**RE: Harnett County Land Use Application HTE08-5-20464**

An attempt was made to evaluate your property for the purpose of issuing an Improvement Permit. The evaluation could not be completed for one or more of the following reasons.

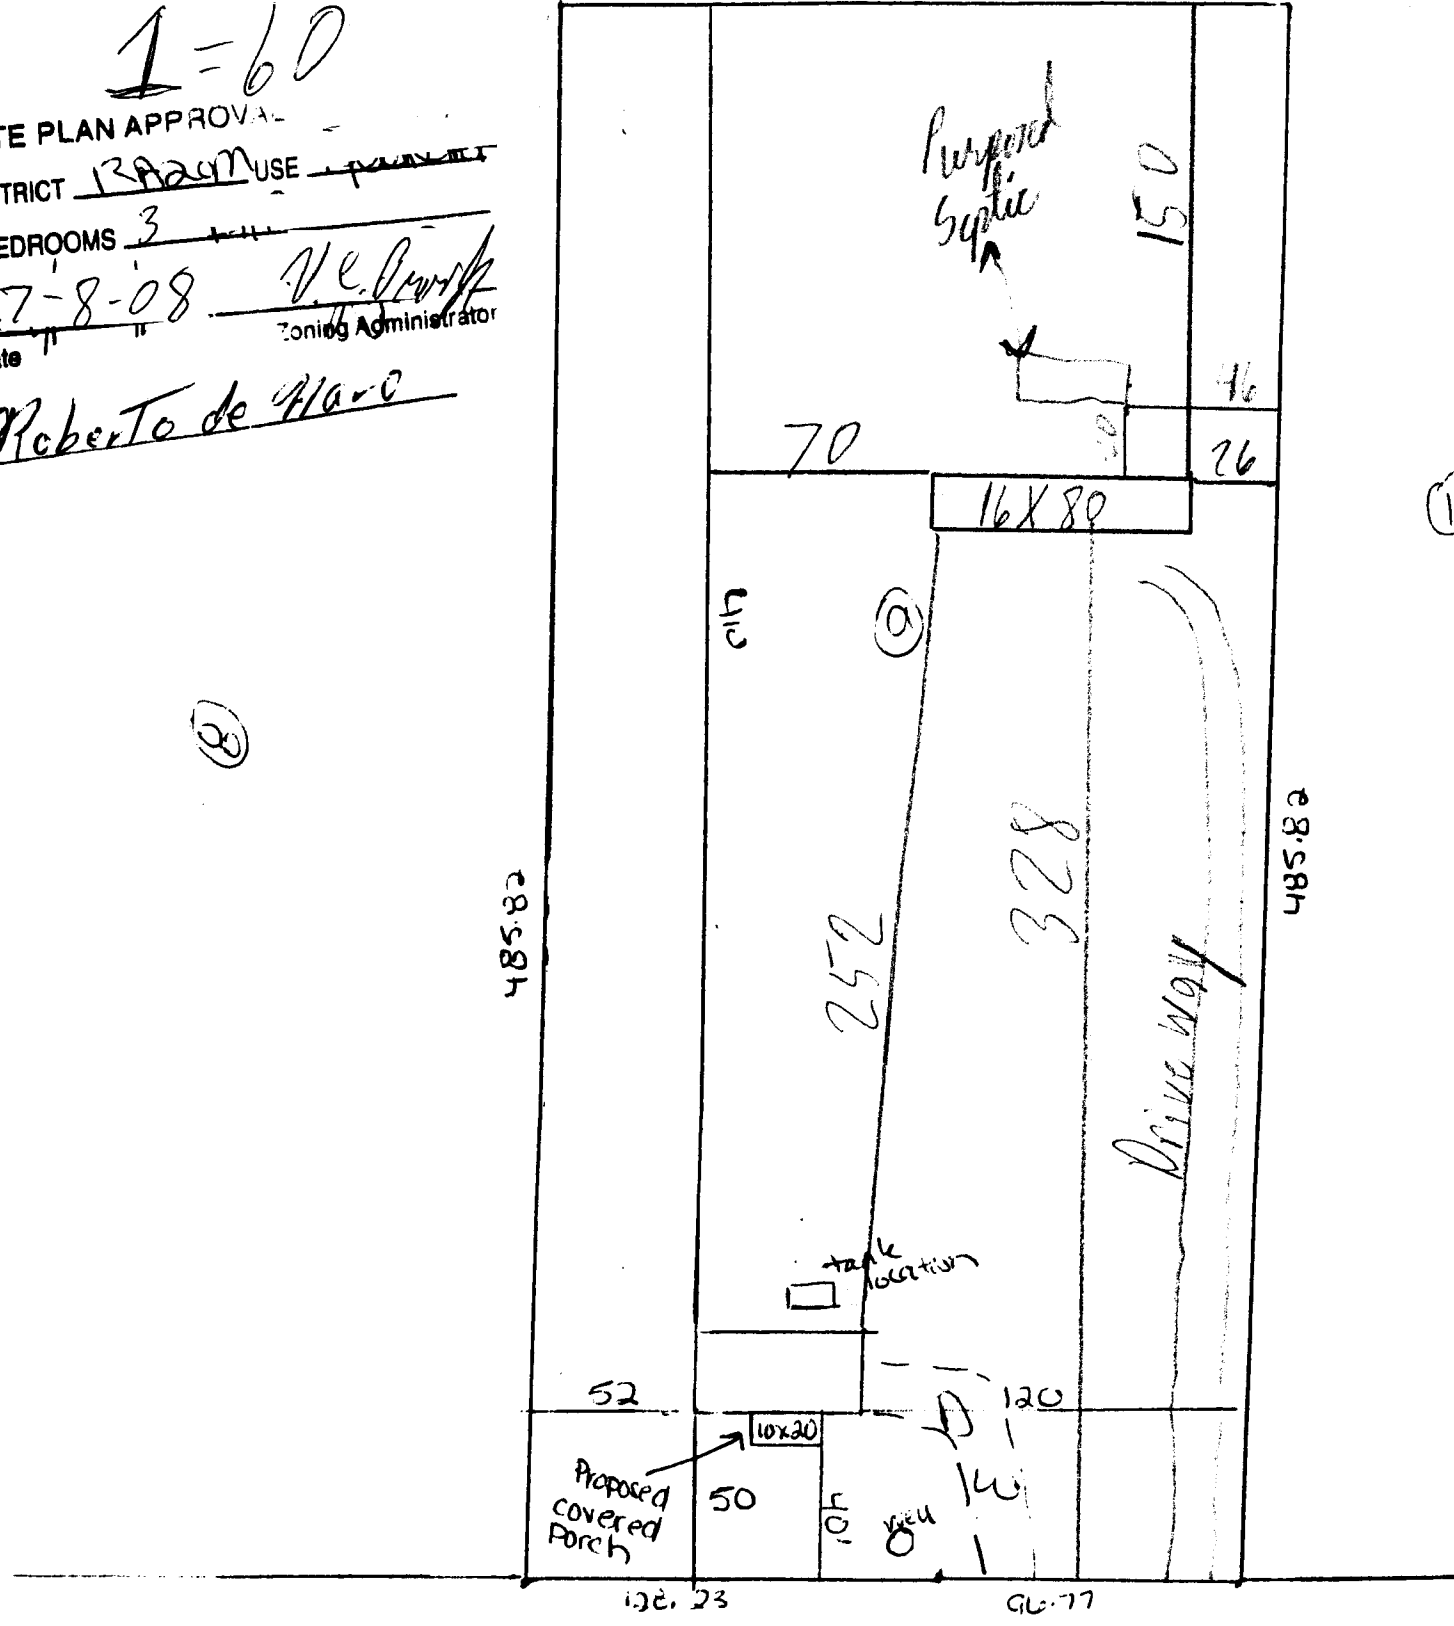
- 1. Property lines/corners not marked or labeled ~ **\$25.00 fee incurred**
- 2. House corners not marked or labeled ~ **\$25.00 fee incurred**
- 3. Directions not clear to property ~ **\$25.00 fee incurred**
- 4. Property needs brush or vegetation removed
- 5. Backhoe pits required
- 6. Other *You will need to cut the trees down, move the house forward 25' go to Central Permitting apply for a revision regarding new measurements and setbacks.*
